From: Amanda Scholes on behalf of Planning.Responses
Sent: 06 December 2019 09:10
To: Planning Scanning
Subject: FW: BR/233/19/PL - 77 Aldwick Road

Many thanks for your email and I have since caught up with Simon regarding your previous correspondence. I also managed to visit the site yesterday and have had an opportunity to review the submission and planning histories to the site. To be clear the issues outstanding at this stage that will be reflected in any subsequent report/decision comprise: (1) Daylighting, (2) Levels of outlook/overbearing impacts, (3) Impacts upon privacy of properties along Stocker Road; and (4) Planning balance. These matters are addressed in the subsequent response below. I understand your concerns regarding the change of case officer throughout the application period but want to re-assure you that this re-allocation is to ensure your decision is expedited as per your previous requests to provide an effective service.

**GROUND FLOOR
PROPOSED FLOOR PLANS**
Scale 1:50

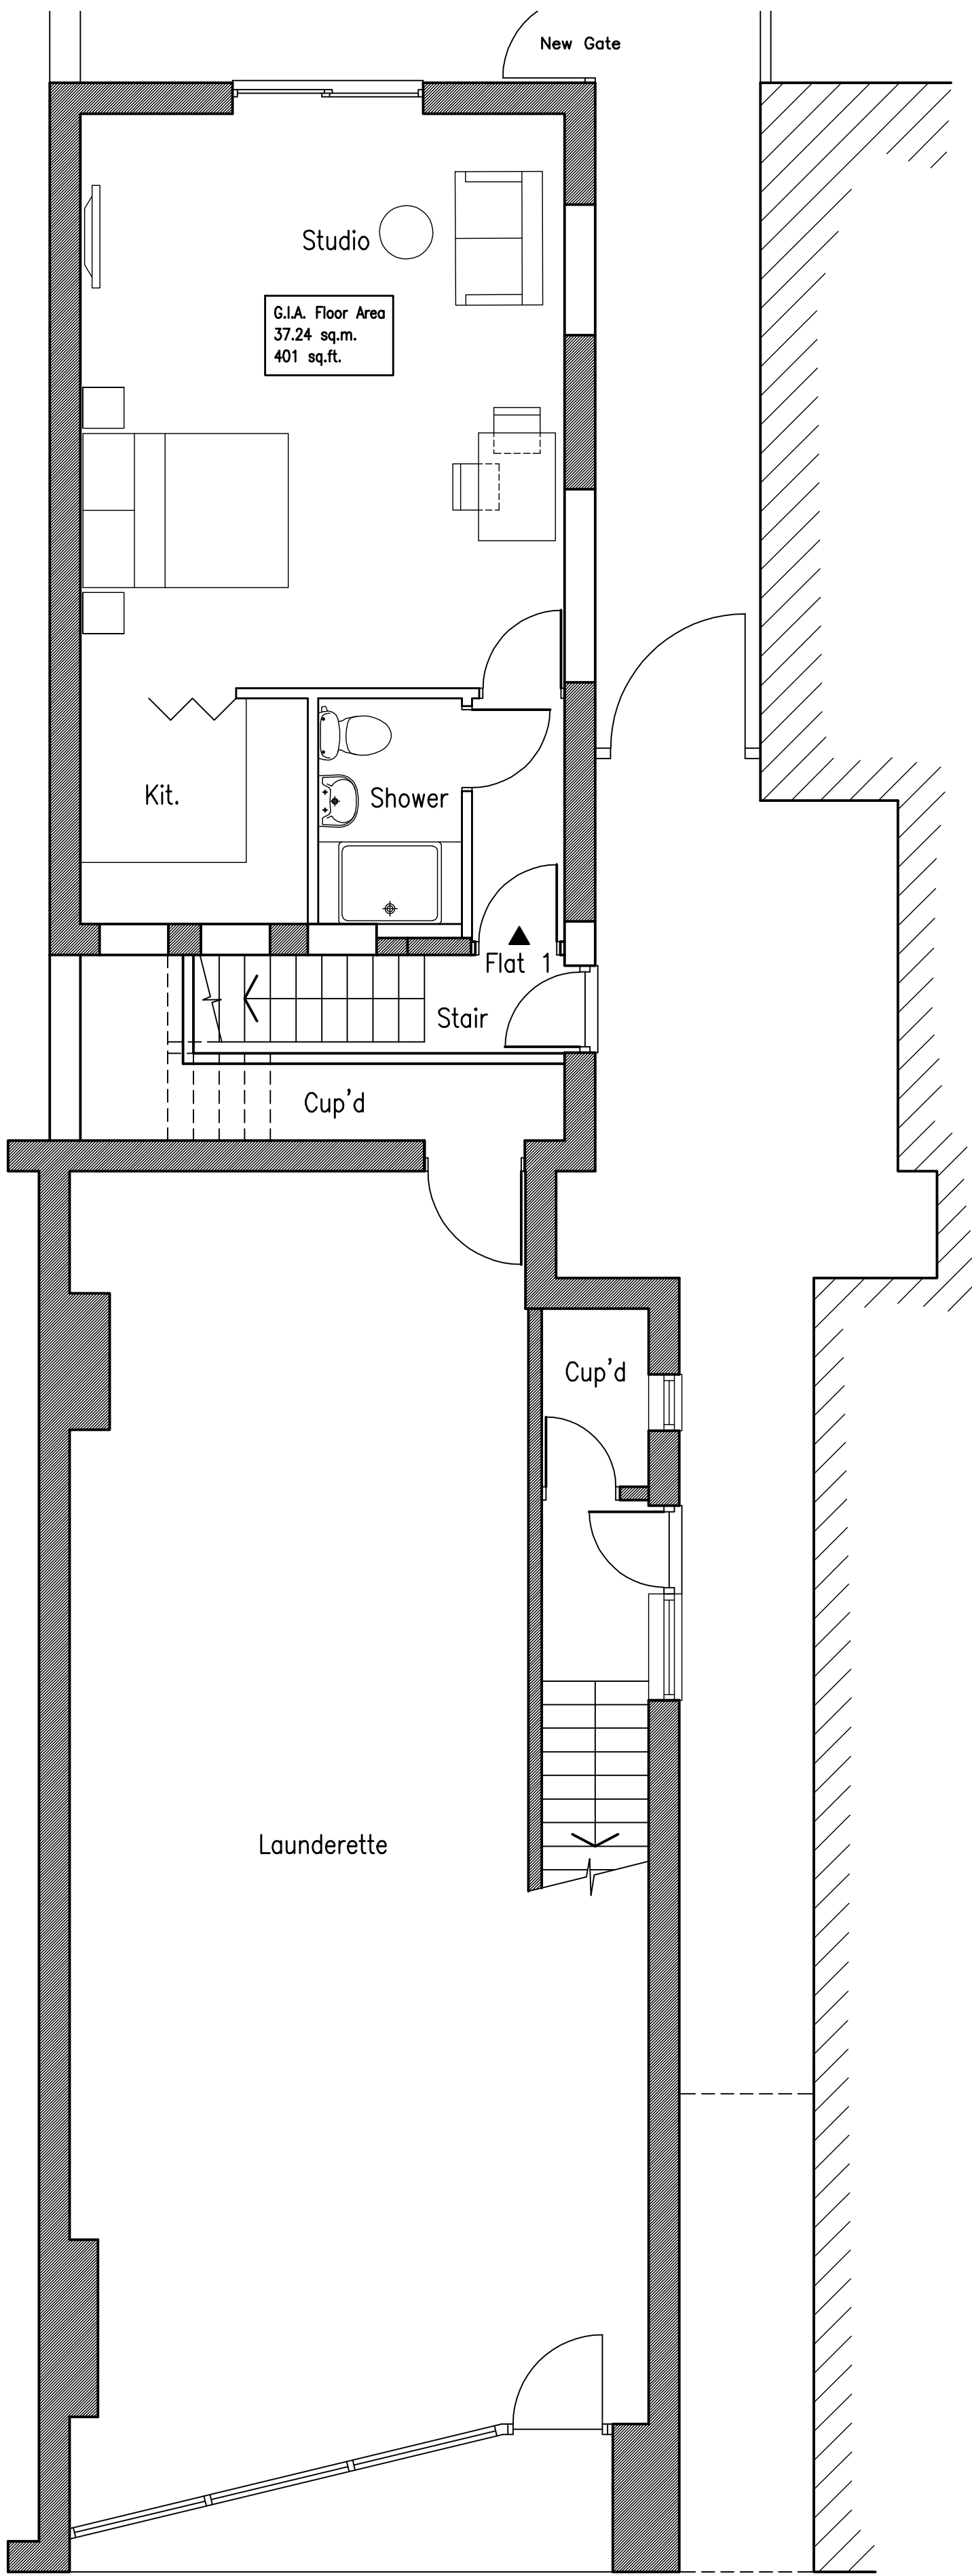
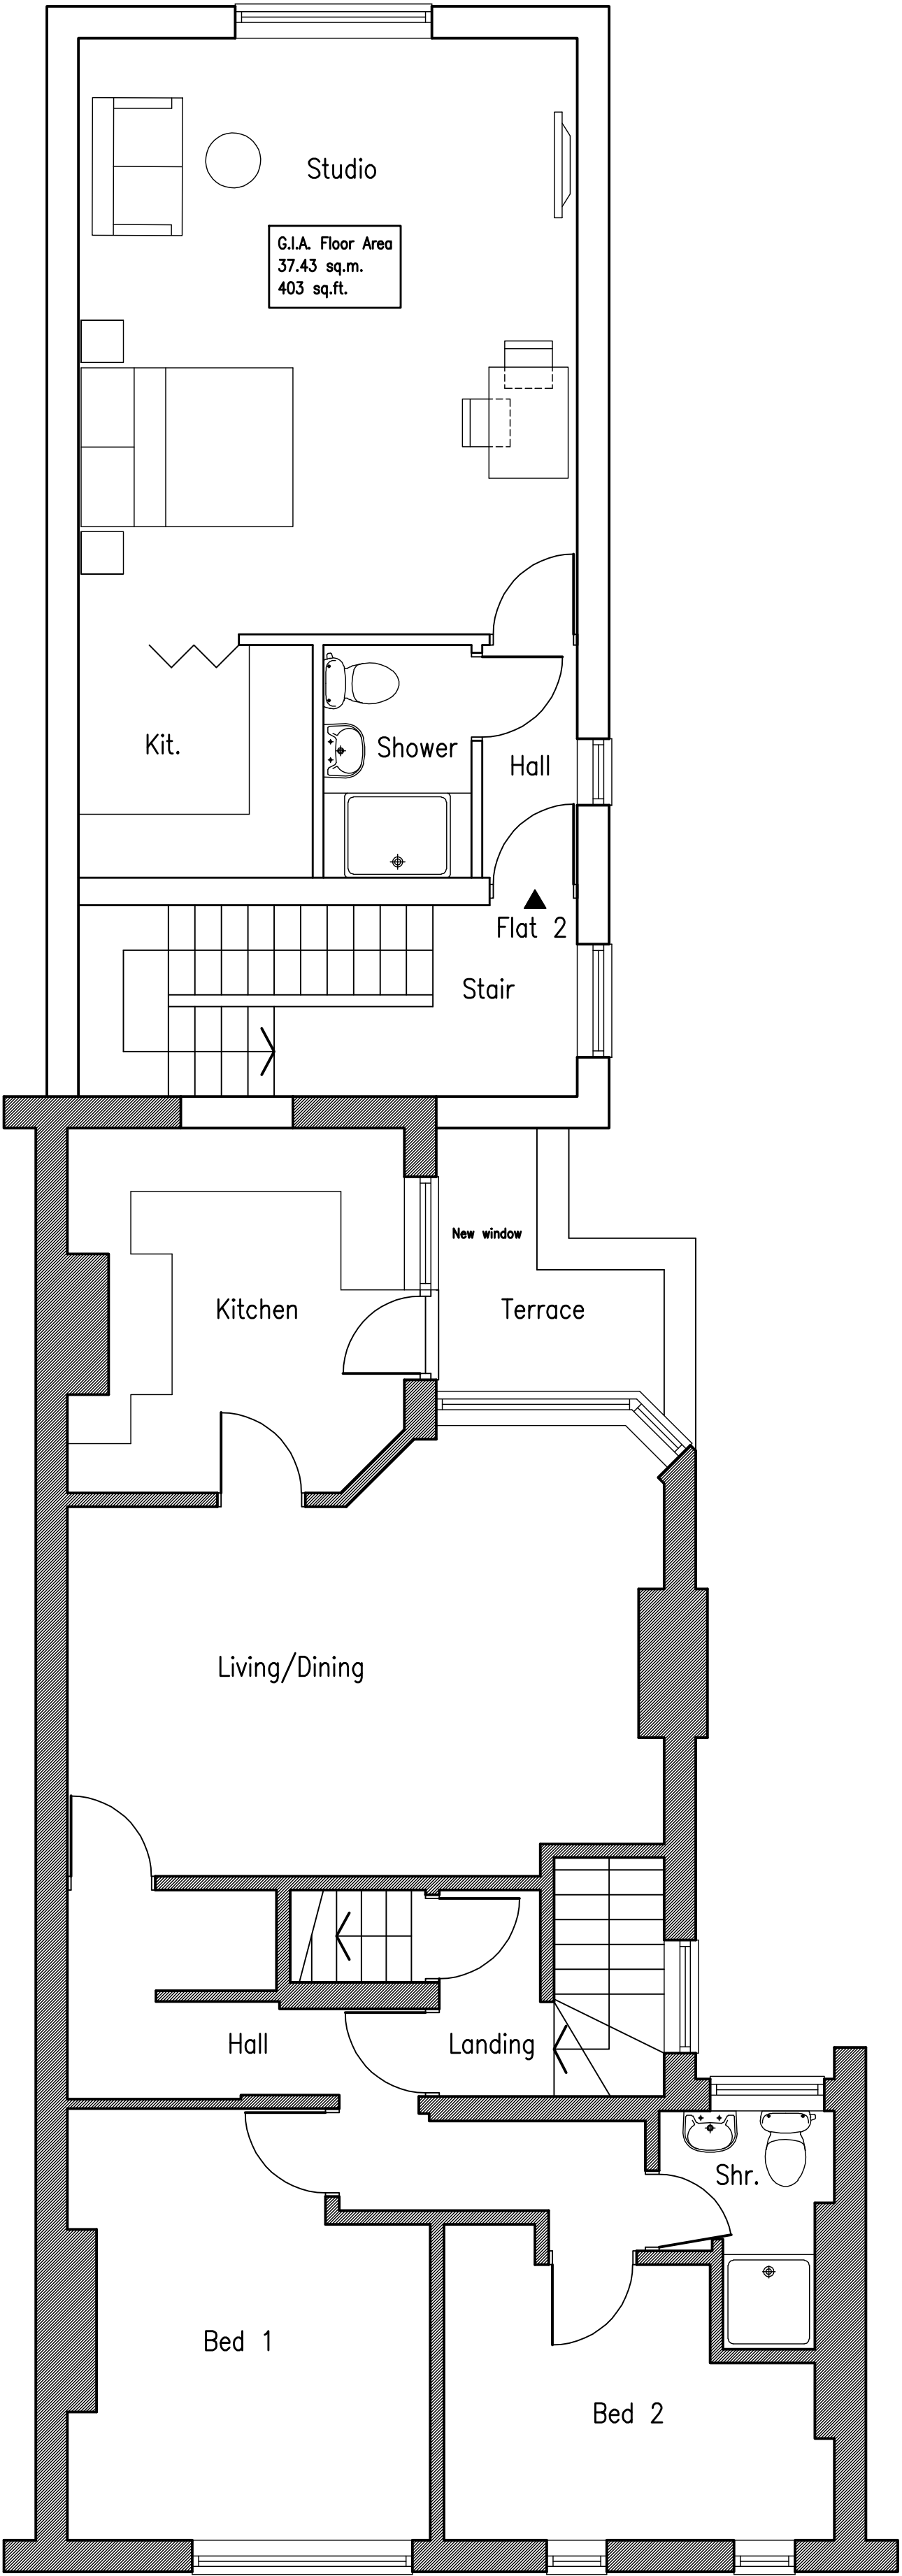
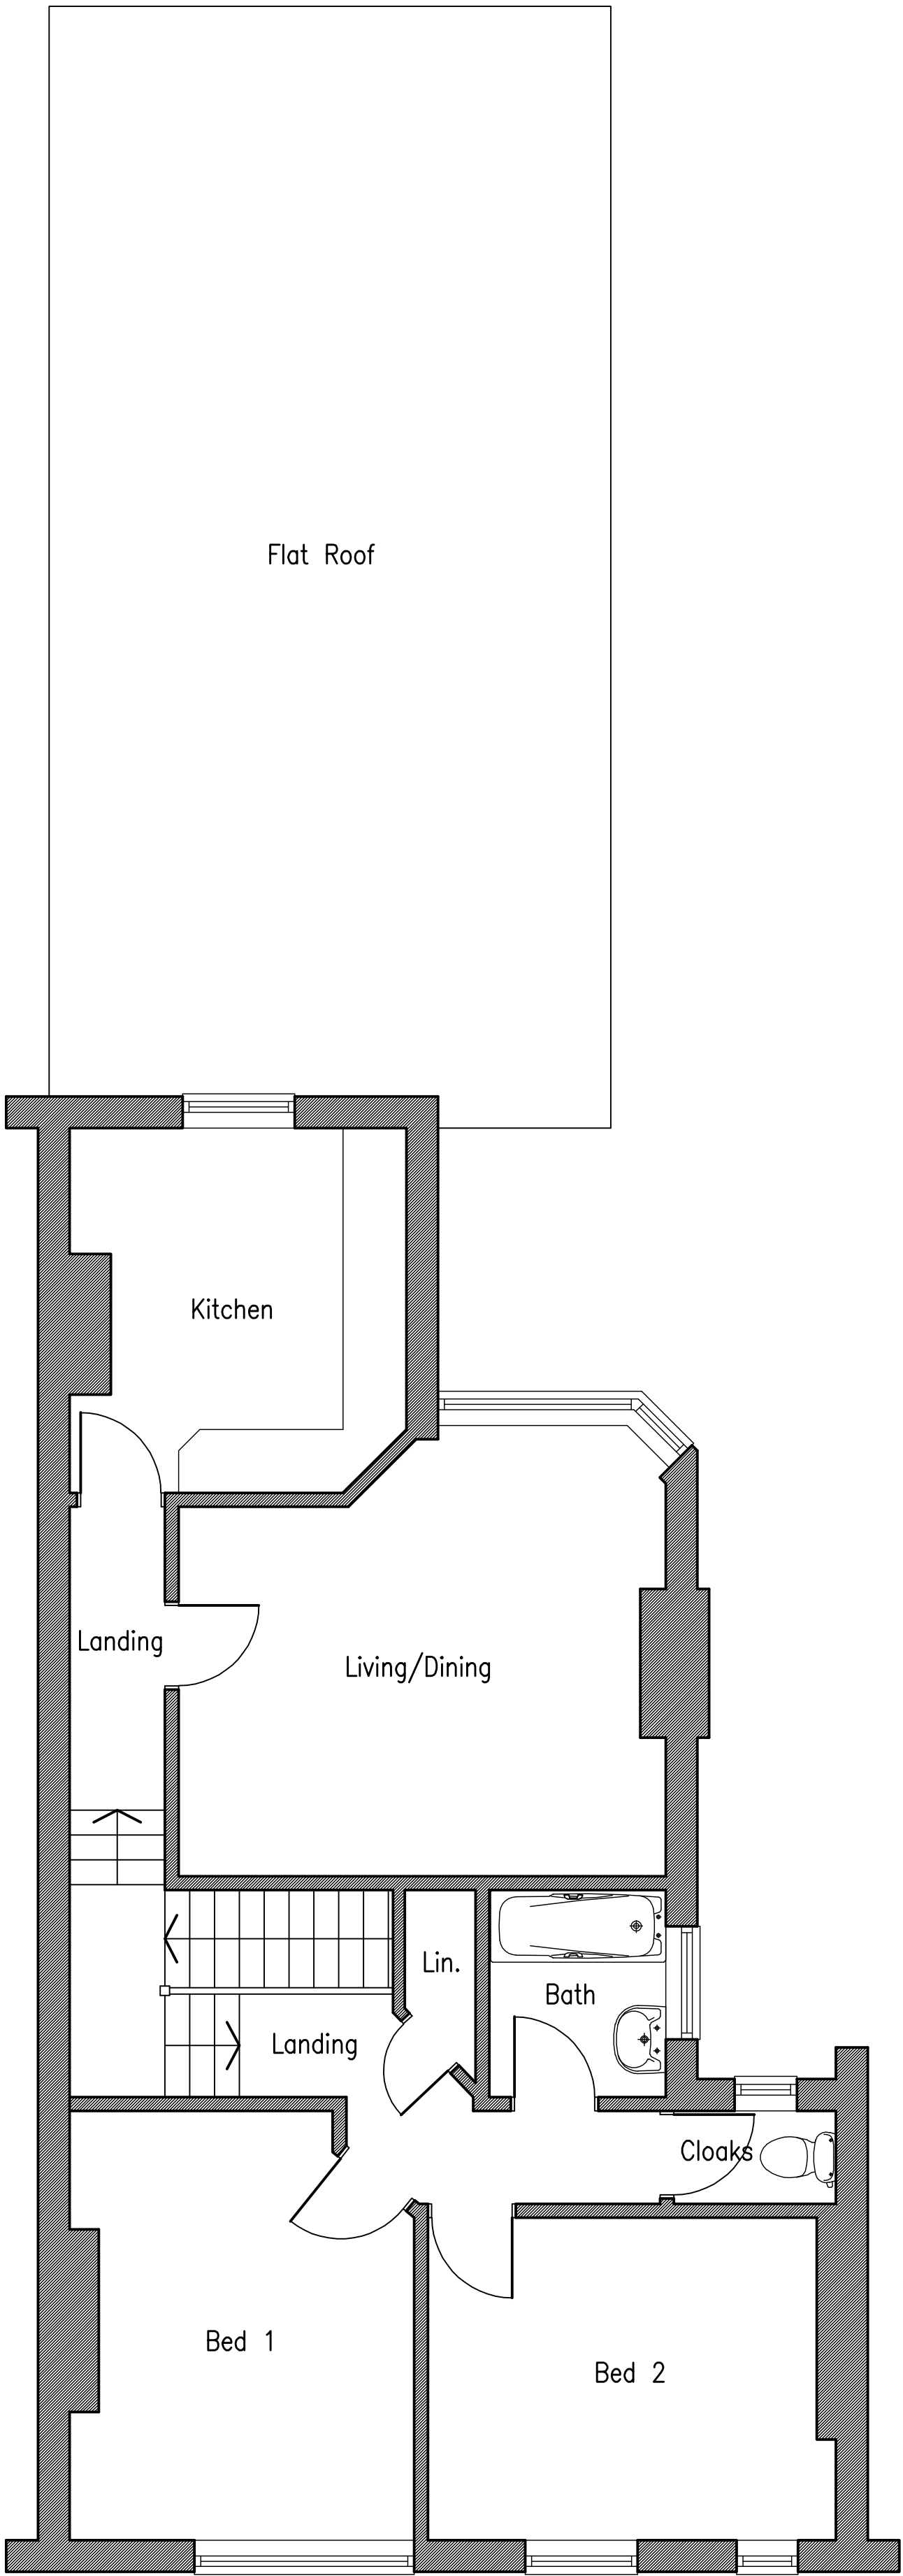
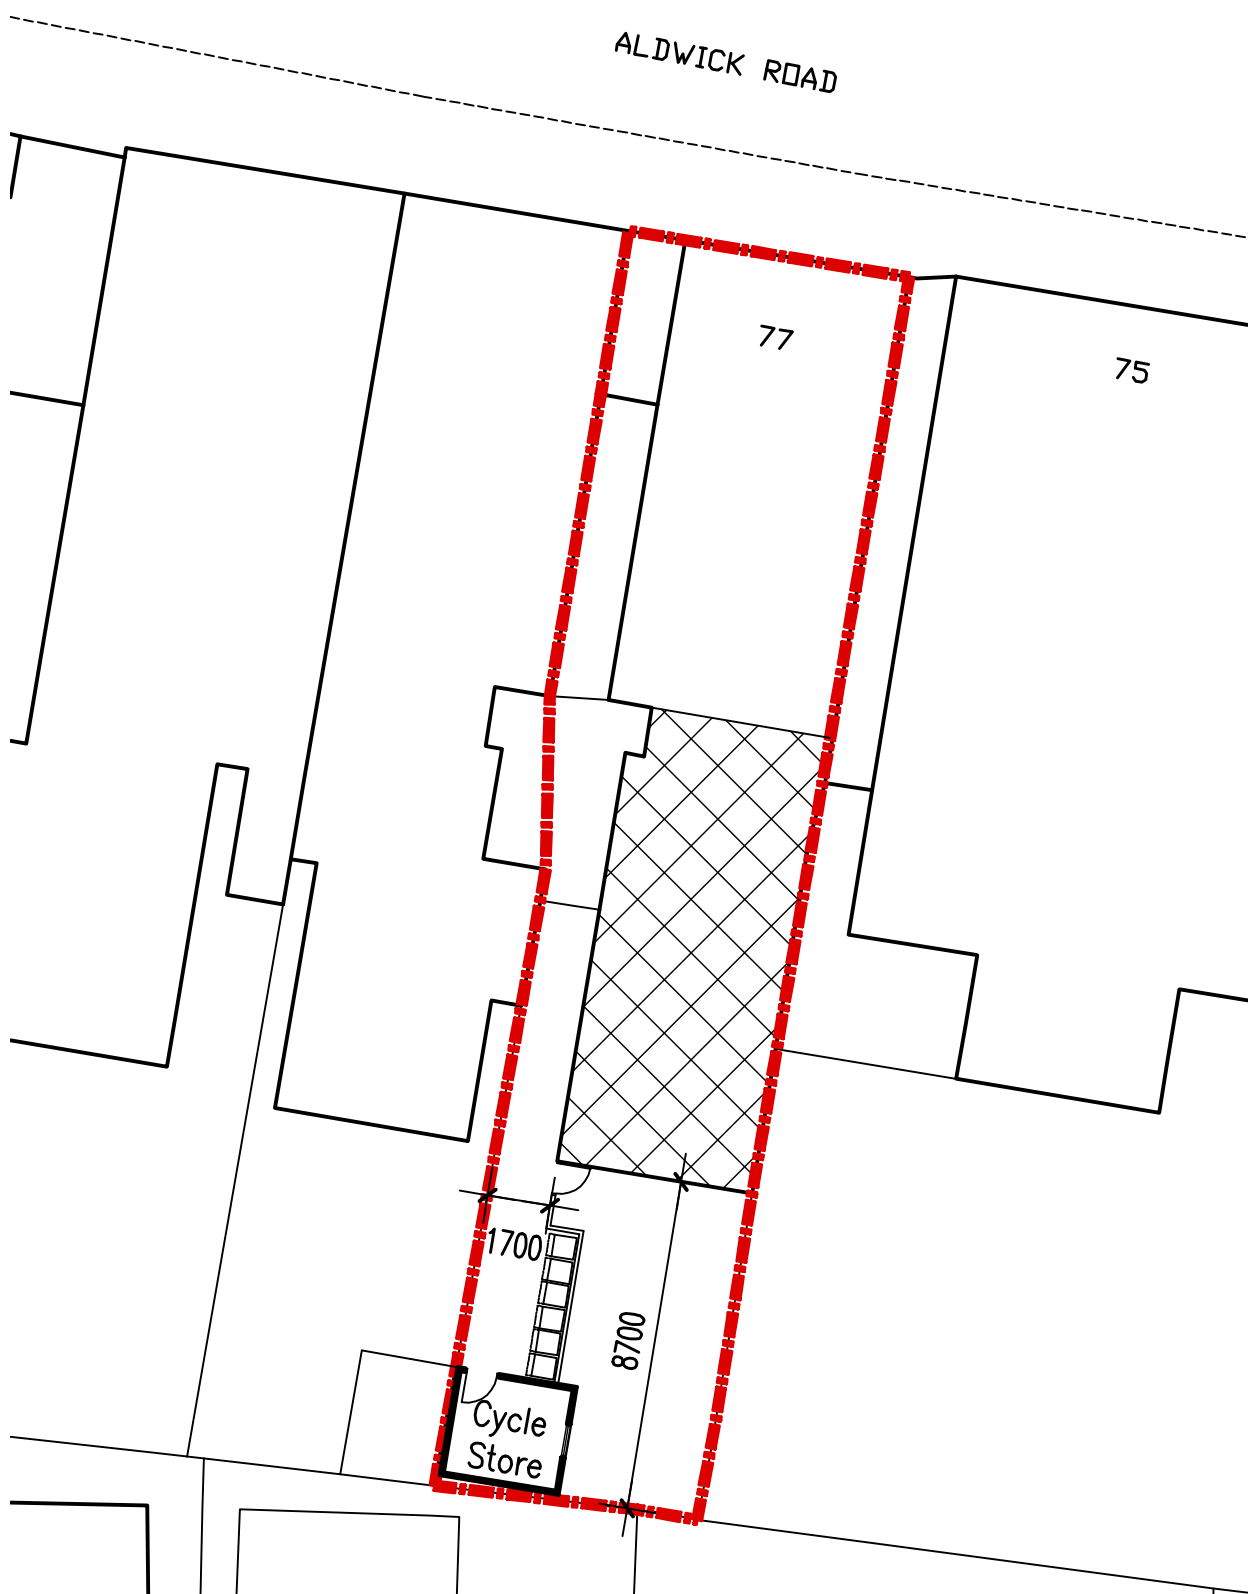
The harm in this instance derives from the provision of the first floor studio apartment. The ground floor apartment is considered acceptable. Therefore, the benefits associated with 1 no. unit have to be balanced against the amenities of 3 no. existing apartments and the loss of privacy to properties along Stocker Road. Taking into account the policies in the Development Plan, contents of the NPPF and matters raised within the application period, the Council is unable to state that the benefits associated with 1 no. additional apartment outweigh the cumulative harm caused to 4 no. existing residential properties, which are afforded protection within Development Plan and NPPF policies.

The relevant windows would be (1) the existing first floor flat's living/dining room window and the terrace/balcony which it shares with its kitchen; (2) the rear/rear side windows and terrace/balcony of the first floor flat on 79 next door and (3) the rear windows of the first floor on 77 next door.
